# A303 Amesbury to Berwick Down

TR010025

**Deadline 2**  
**8.10.17 Waste and Materials Management (WM.1)**

#### Waste and Materials Management (WM.1)

Figure 4-1: Potential On-site Locations for Deposition of Tunnel Arisings

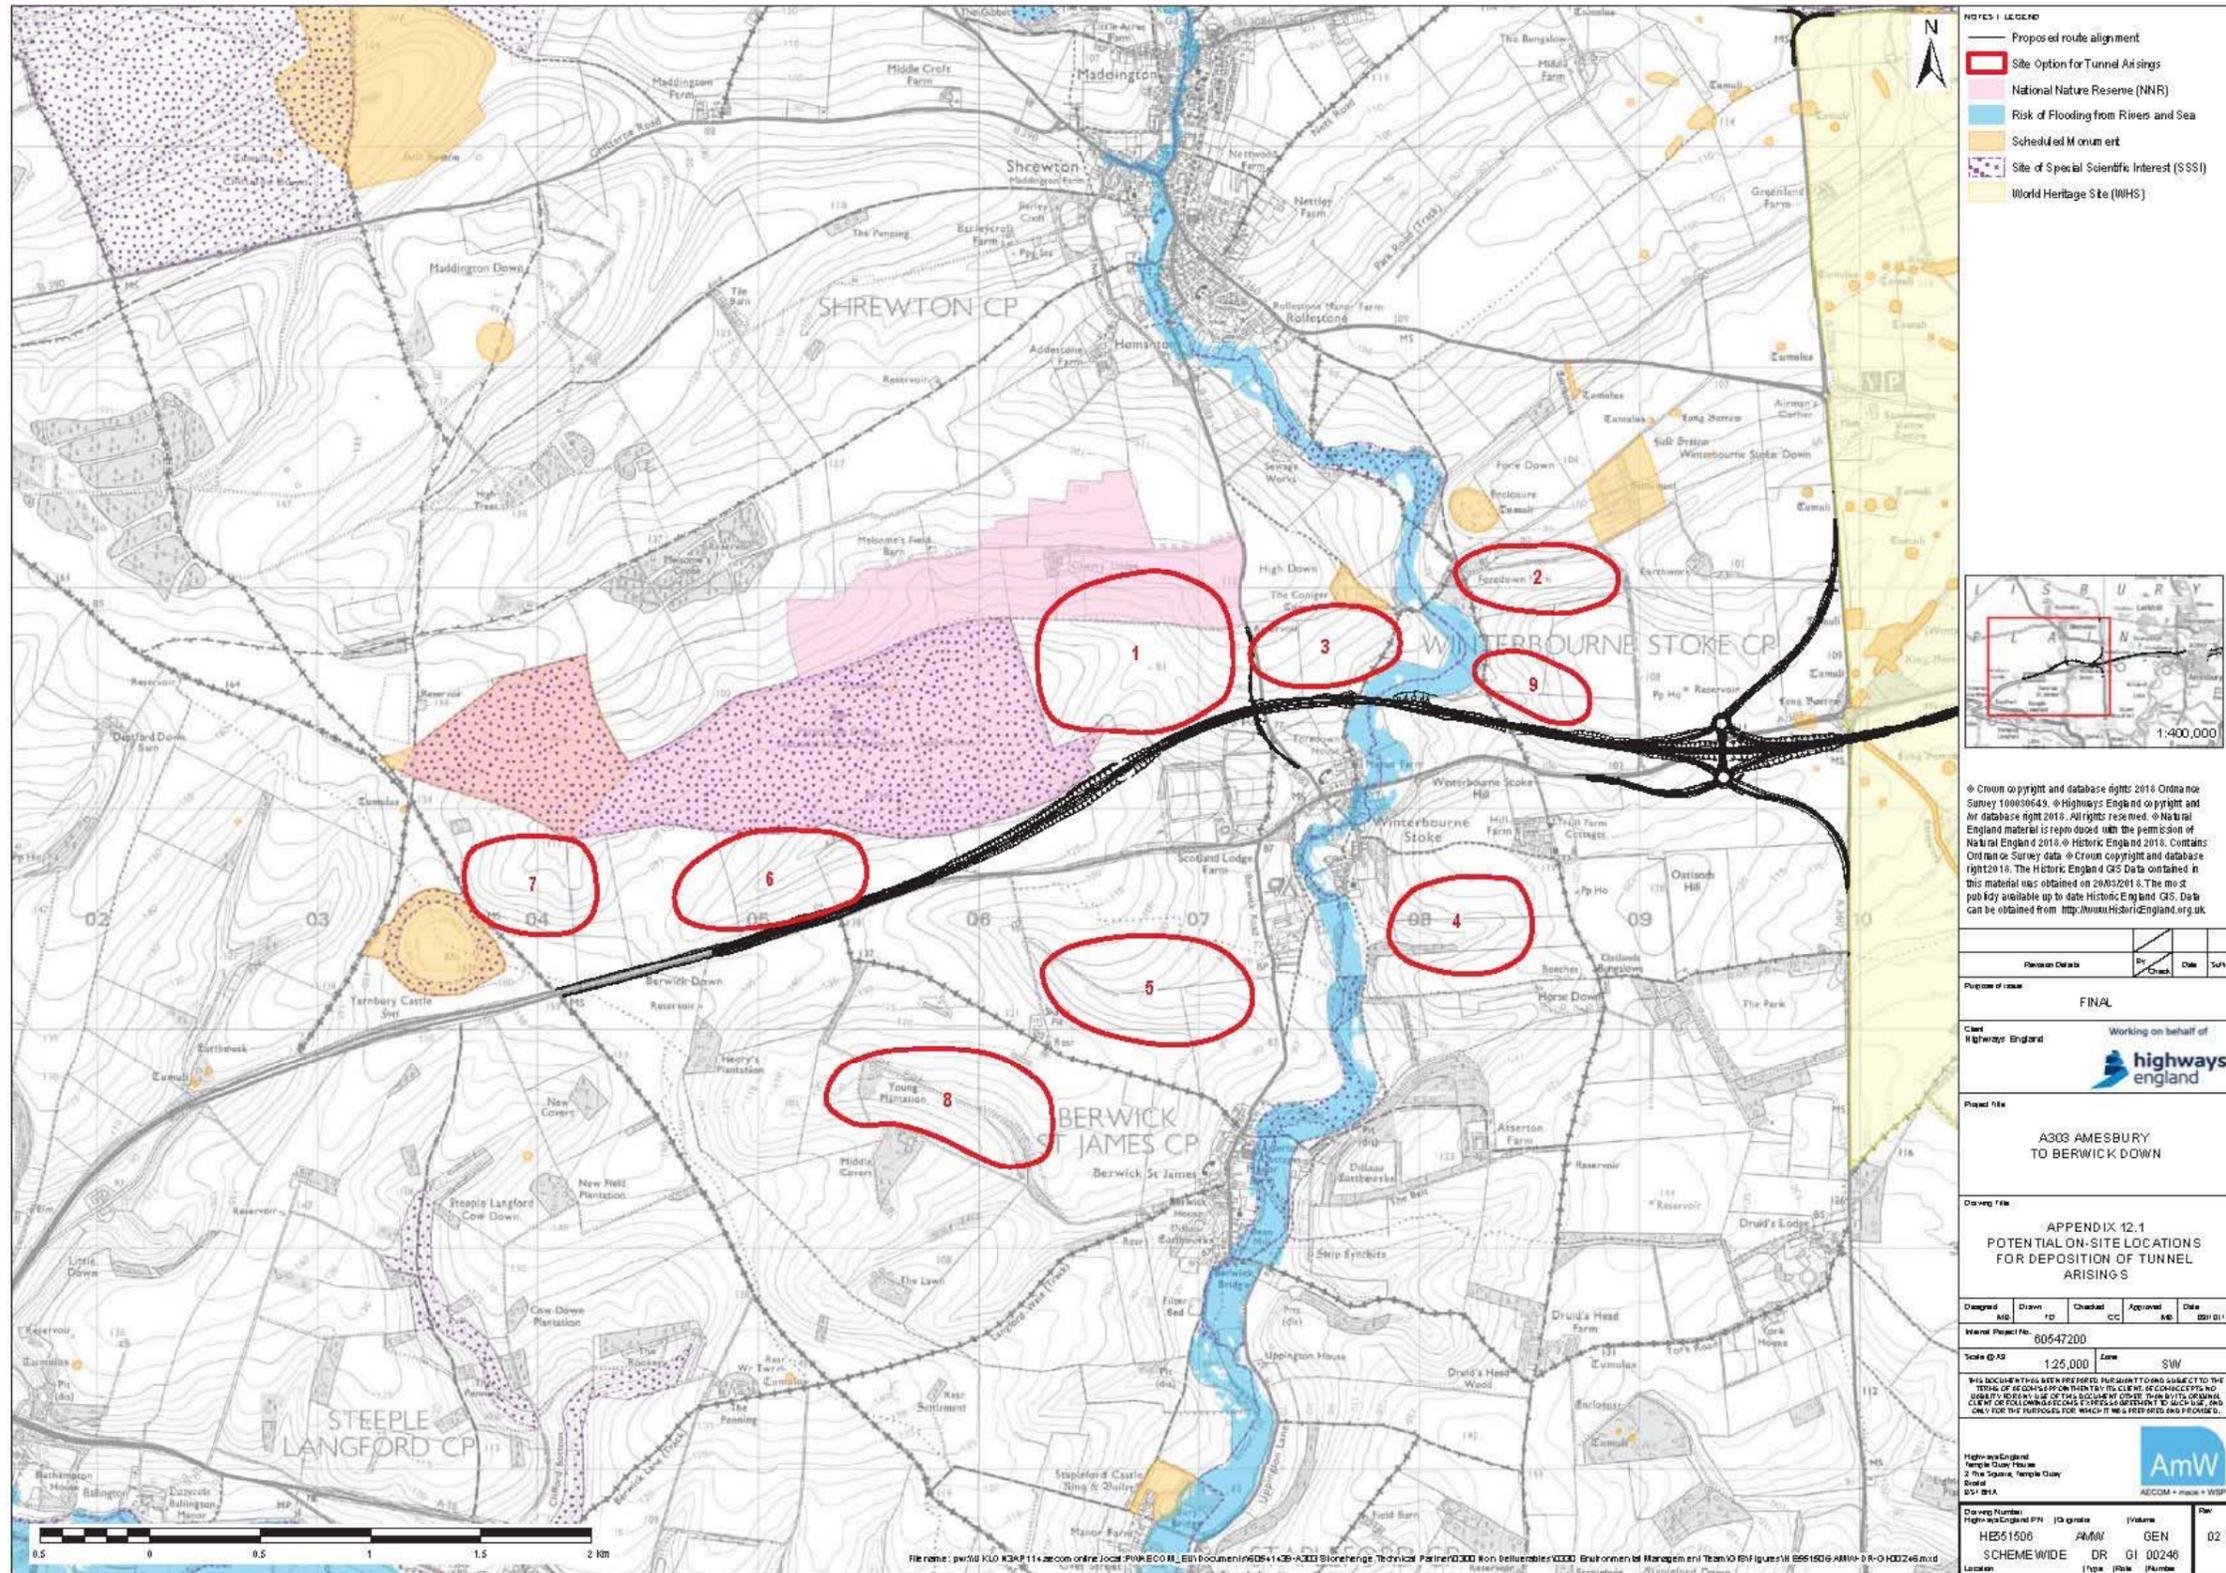
There is an apparent contradiction between the plans presented within Figure 4-1 [APP-285] and Work Plan (Work No. 8) [APP-008] in respect of how the land east of Parsonage Down NNR has been represented.

Can the Applicant confirm the correct area for the placement of the 500,000m<sup>3</sup> of tunnel arisings; and what, if any, effect the anomalous detail in the plans has on the assessments in the ES?

2. With respect to Figure 4-1 [APP-285], the extent of the land east of Parsonage Down is indicative only, for the purposes of the comparative assessment between different options in the vicinity of the Scheme that is presented in the Tunnel Arisings Management Strategy [APP-285].
